From: Martyn White
Sent: 05 October 2018 16:19
To: Planning.Responses
Subject: BR/198/18/HH

BR/216/18/L

The proposal is for the demolition of an existing outbuilding, and the erection of a two storey extension.

Proposed street-scene

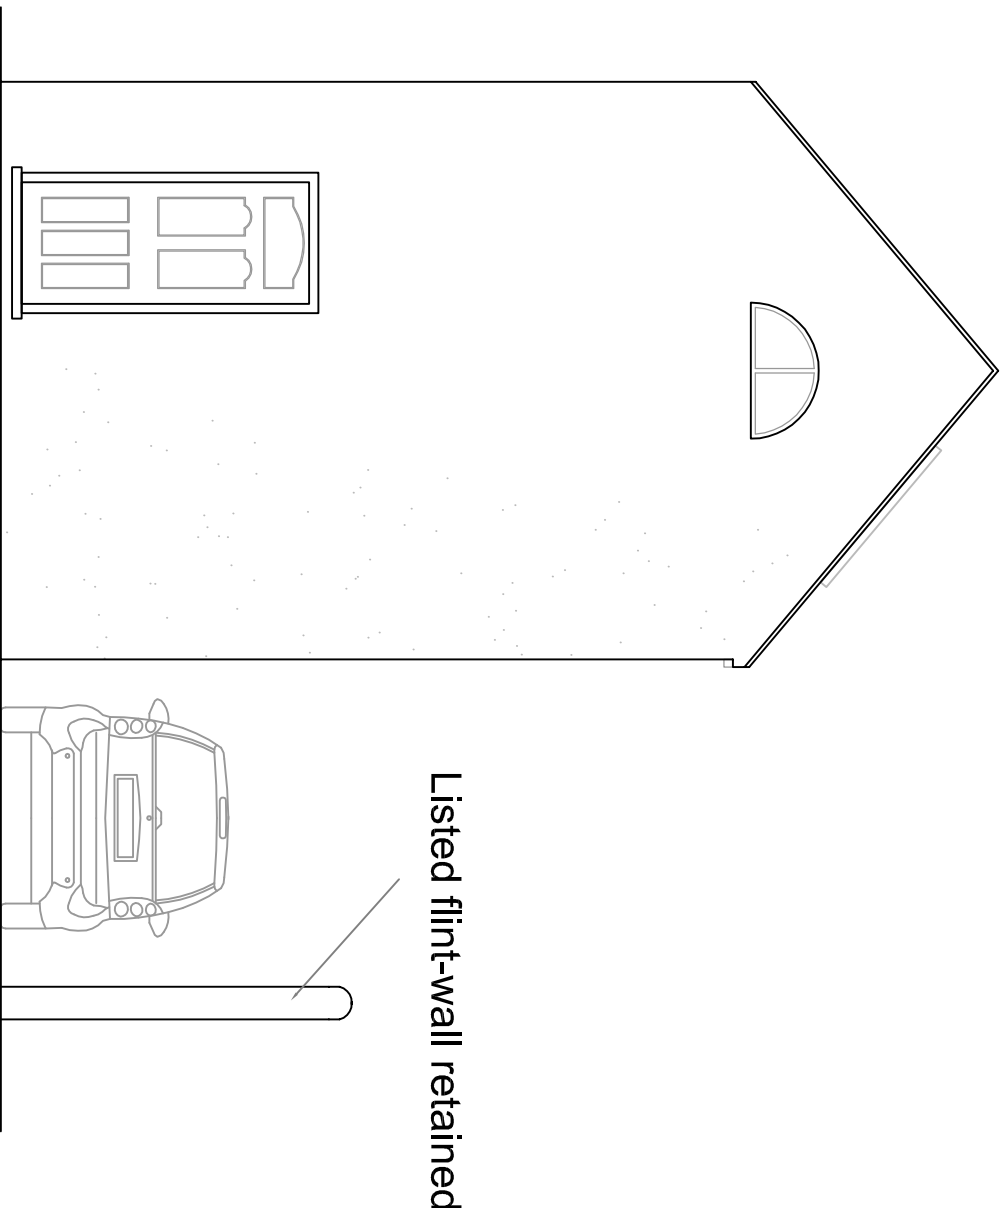
Looking at the proposed elevations, it looks as if the proposal results in the loss of an original/older sash windows. Such a proposal cannot be supported. The use of French windows complicates the elevation and is in contrast with the simple nature of the building. The proposed east elevation contains a single door and small first floor window which does not make a positive impact upon the street-scene.

Scale 1:50		Applicant: Angela Taylor Address: Milford Cottage Bognor Regis PO21 1TD	
Project: Two-storey extension		Revision date: PLA002	
Scale: 1:50 @ A1		Date: 11/07/2018	
Title: Proposed floor plan and elevations		Plan No: PLA002

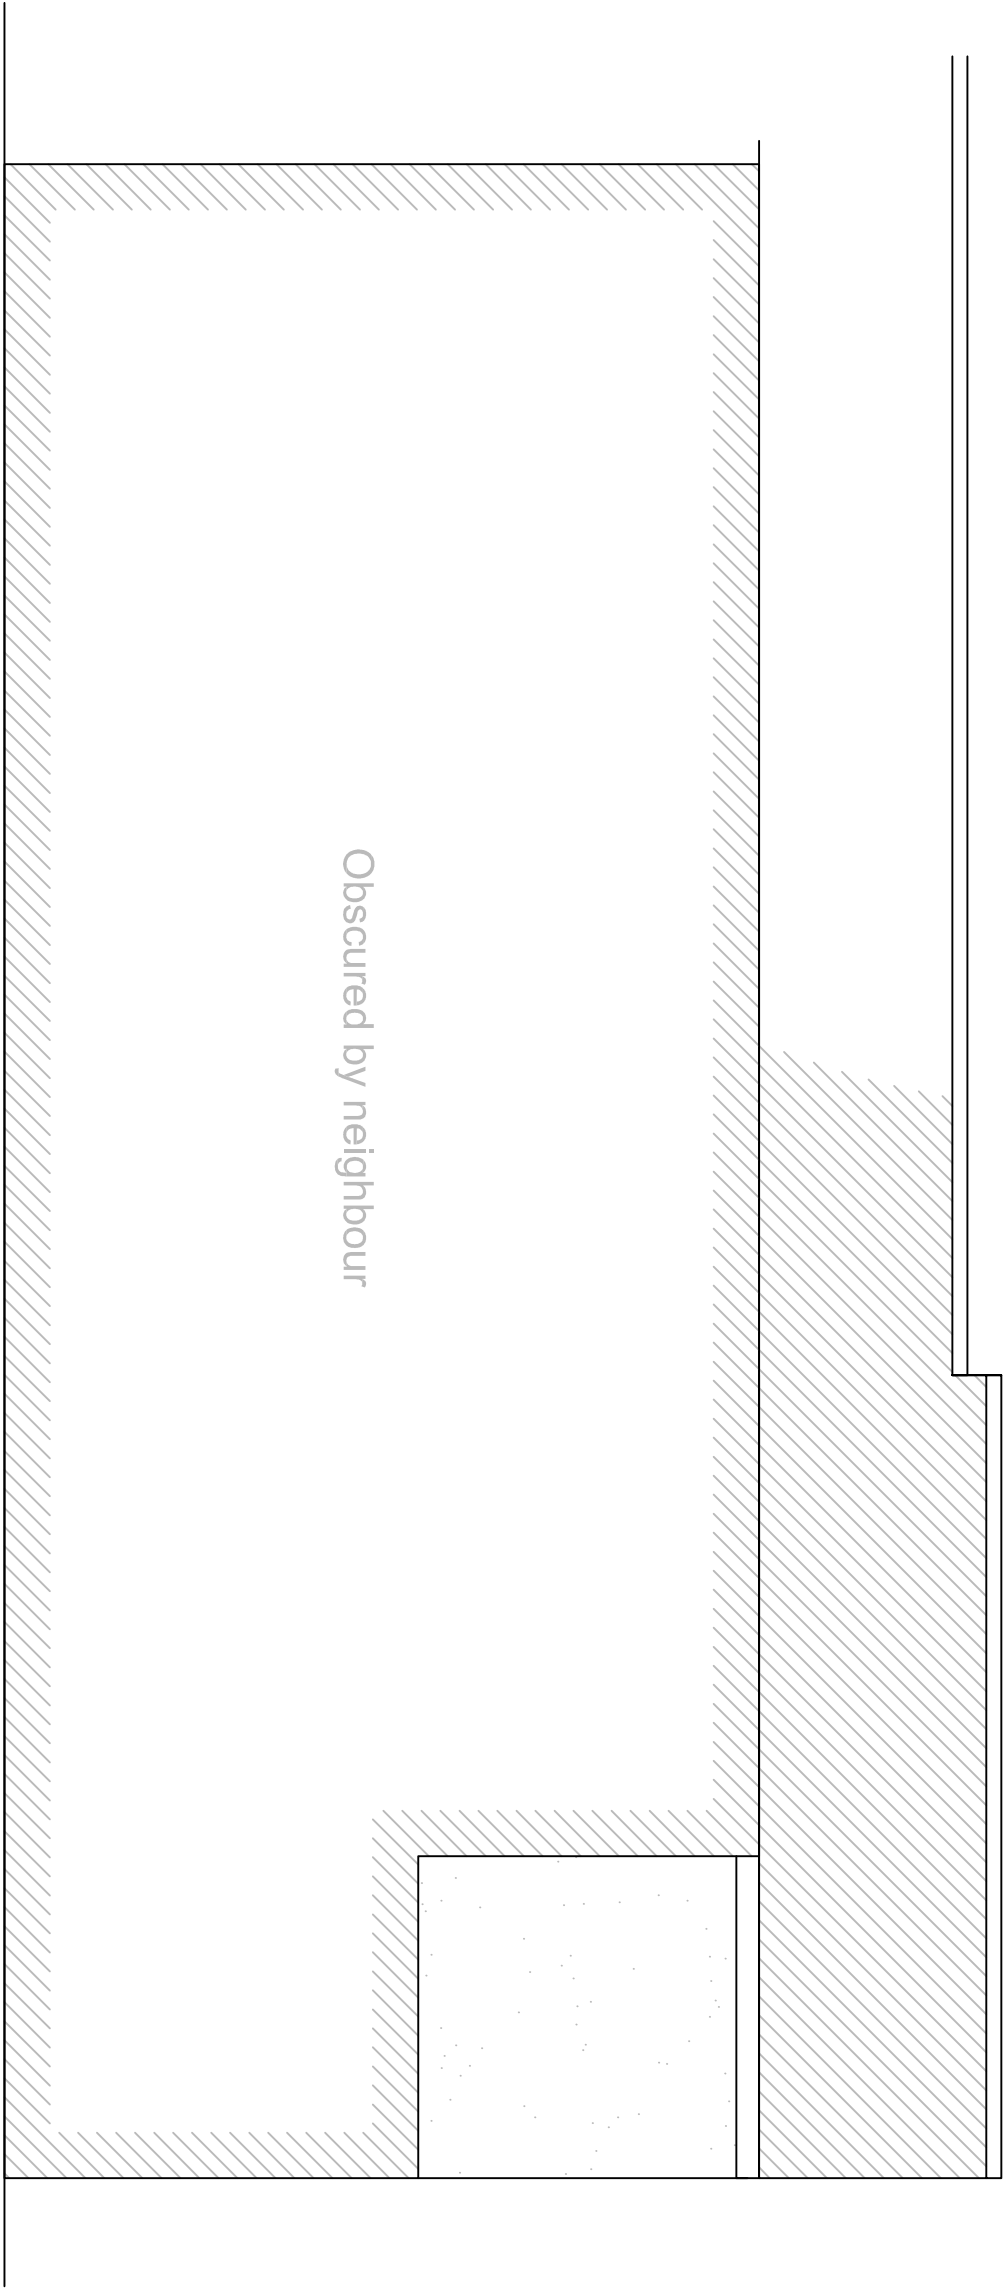
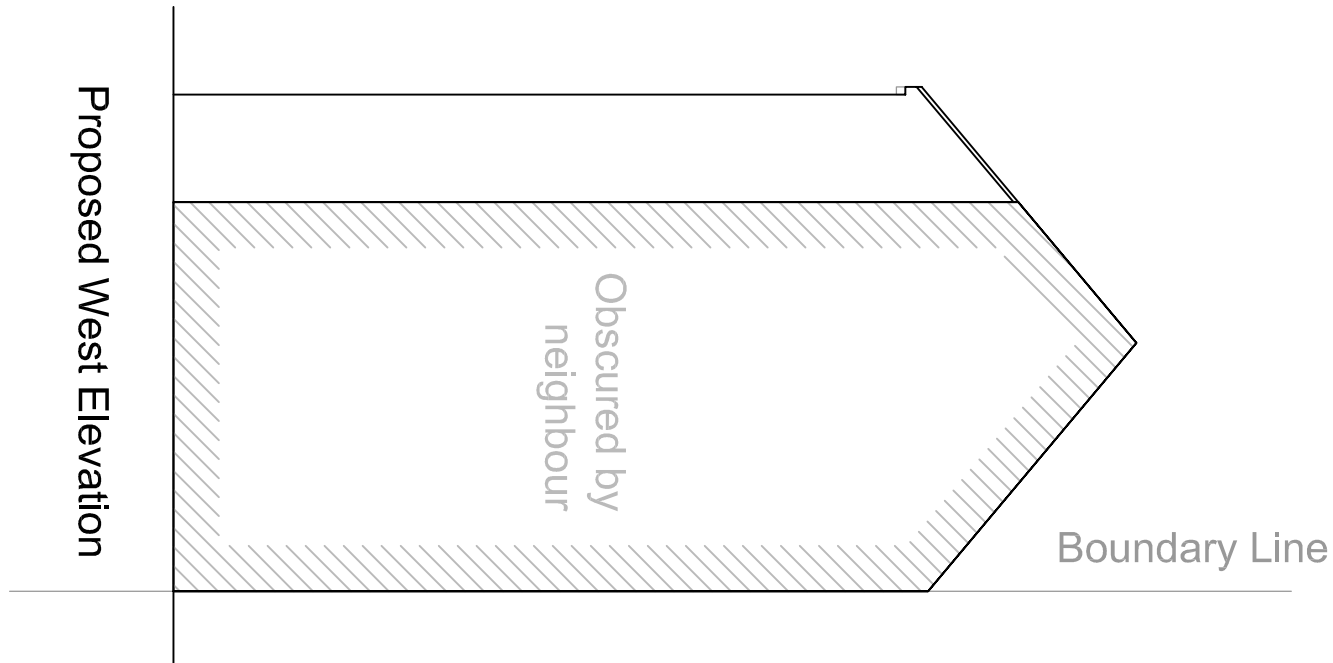
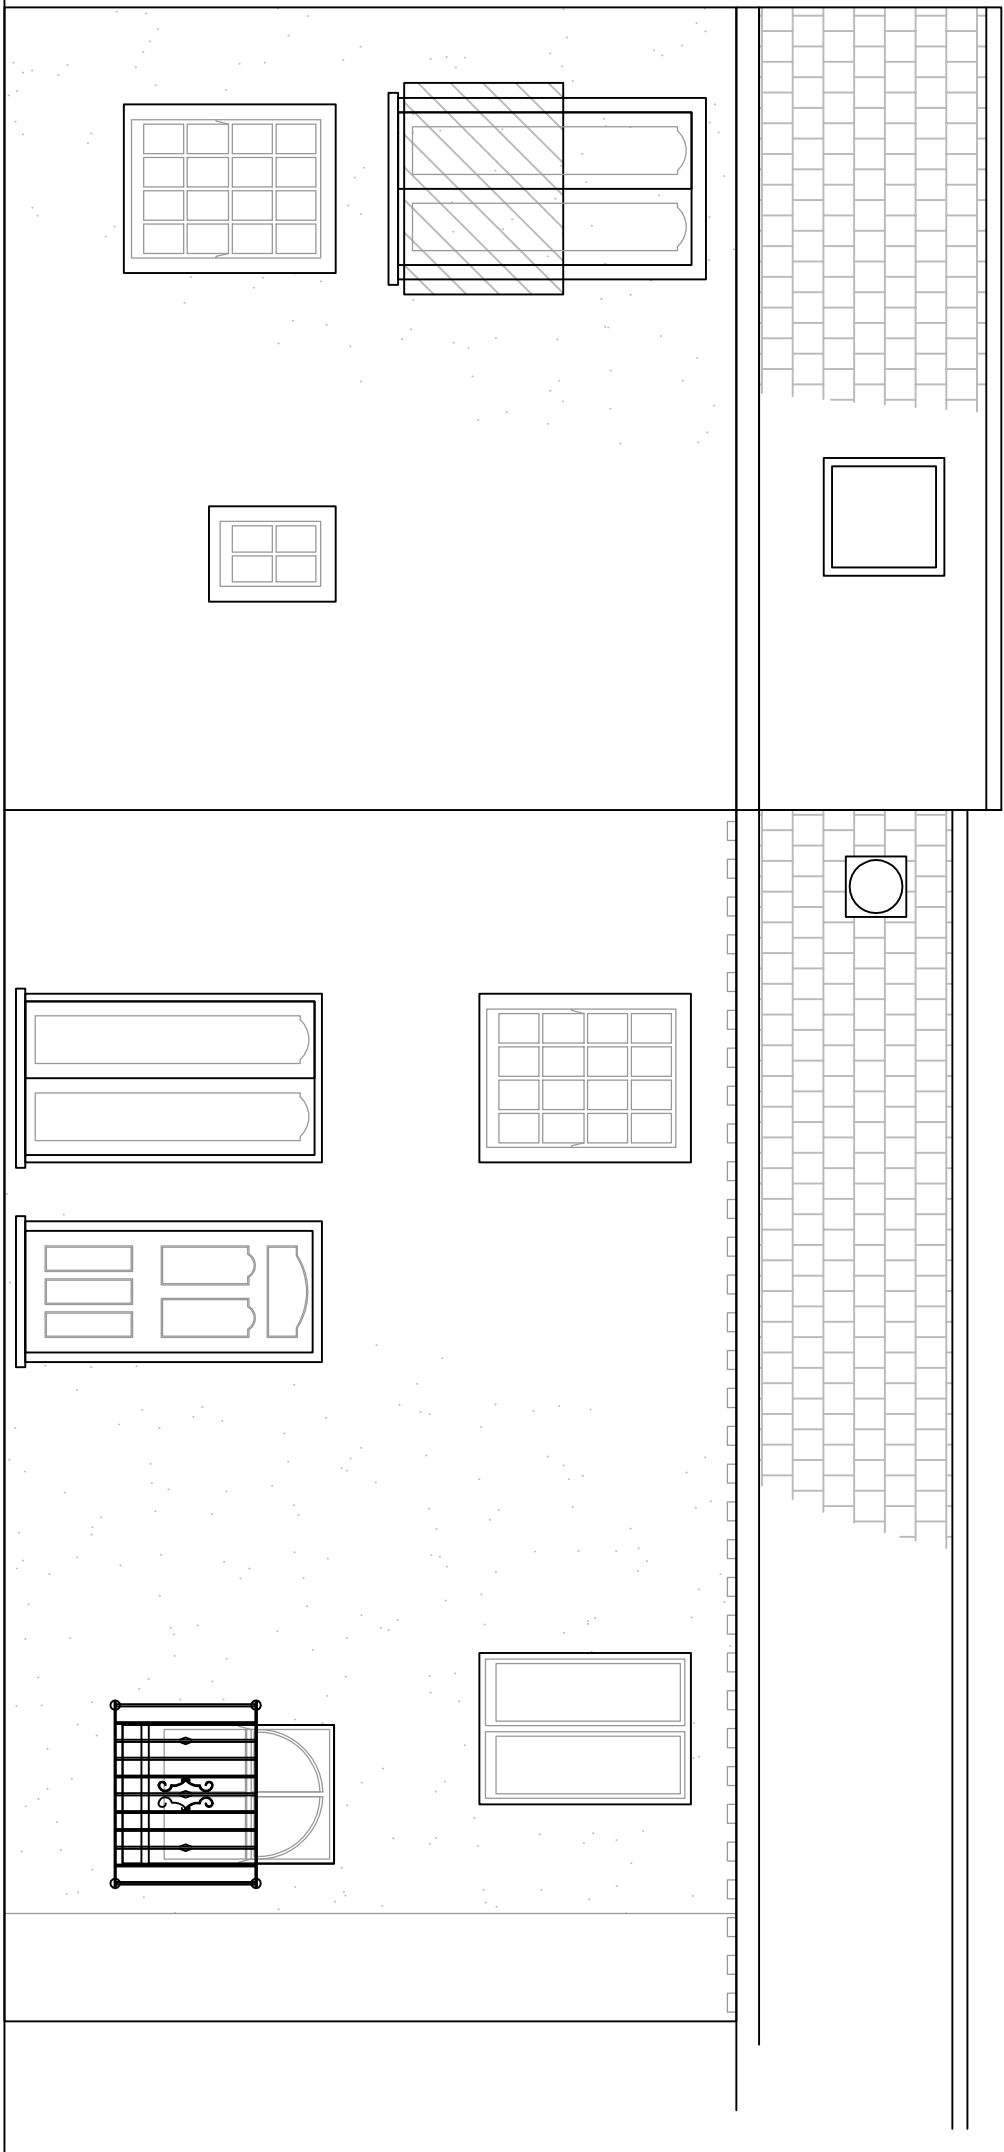
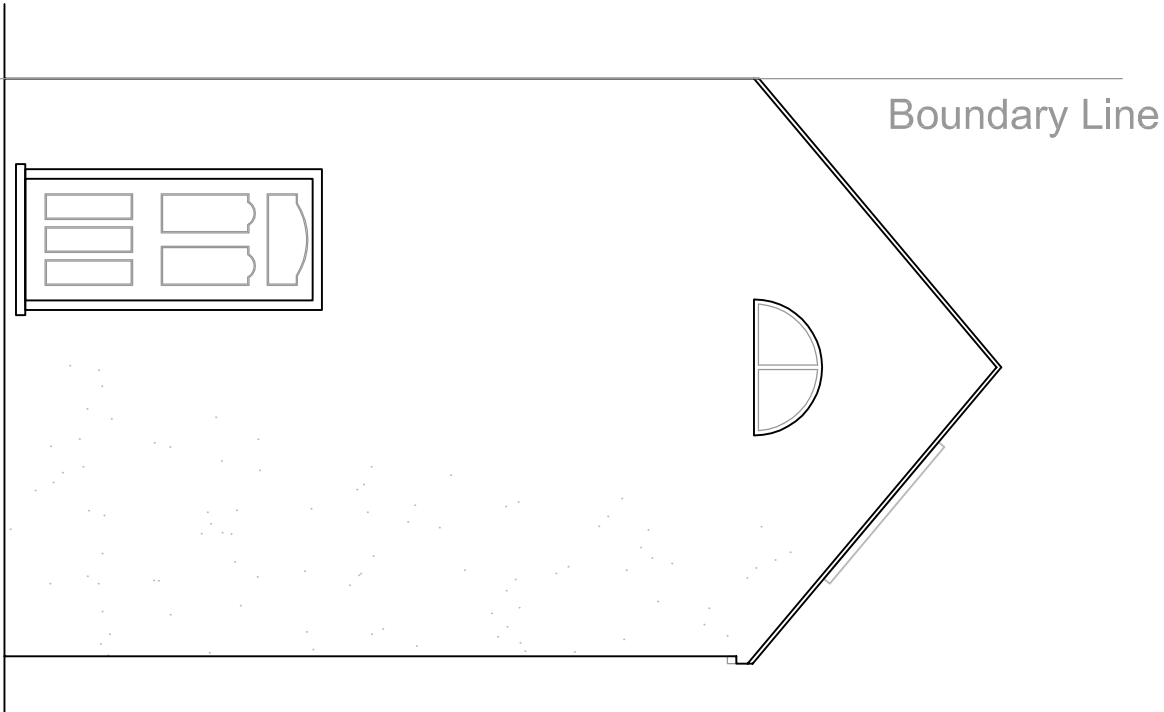
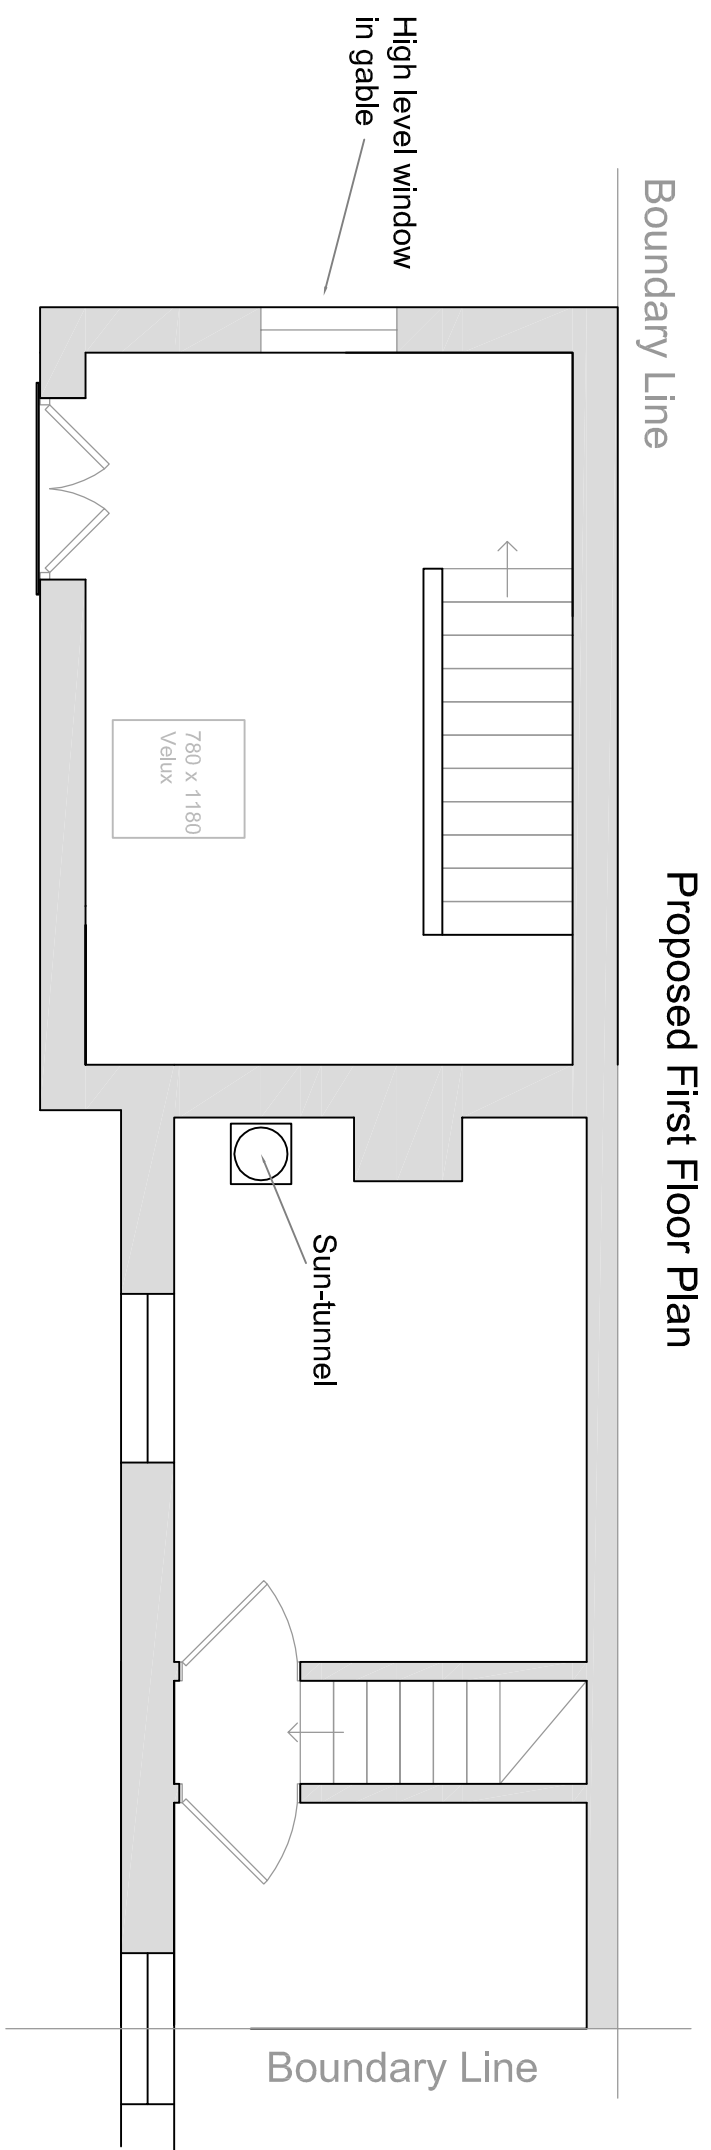
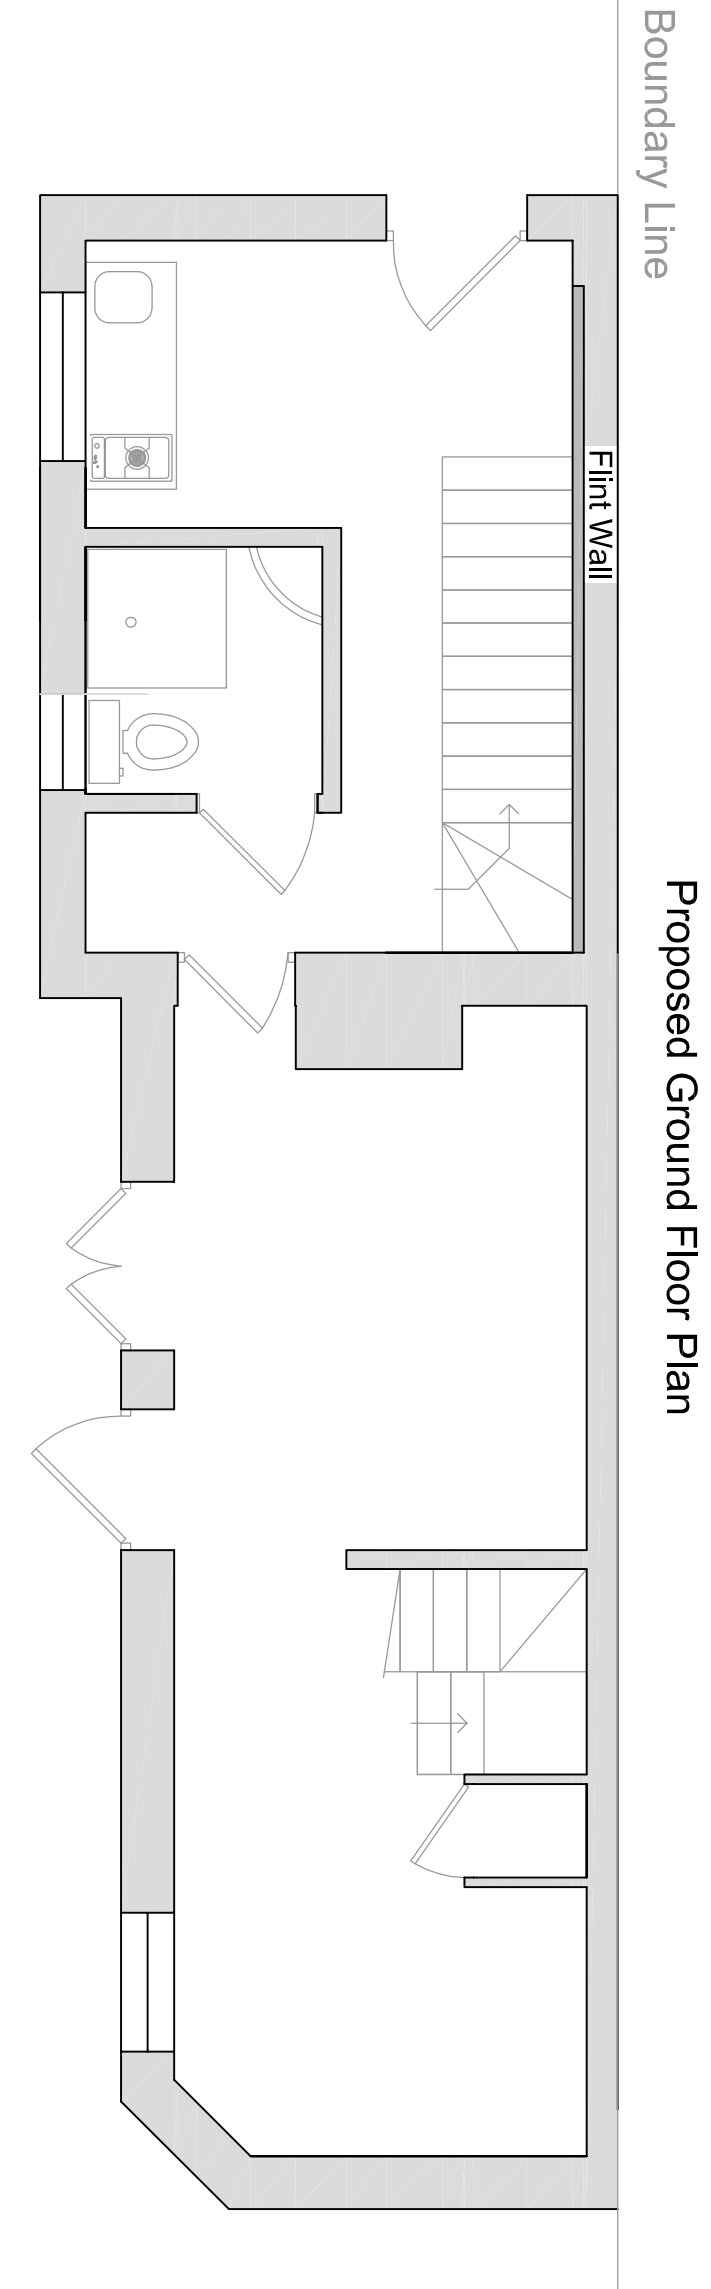
The proposed two storey extension, on the other hand, is considered problematic and cannot be supported in its current form. The extension is considered to be substantial in nature and is wider than the host dwelling. It therefore cannot be considered to be subservient to the host dwelling. In addition, it seems to accommodate a significant amount of the curtilage with very limited uses; a bedroom, shower room and a large area of hallway/corridor space.
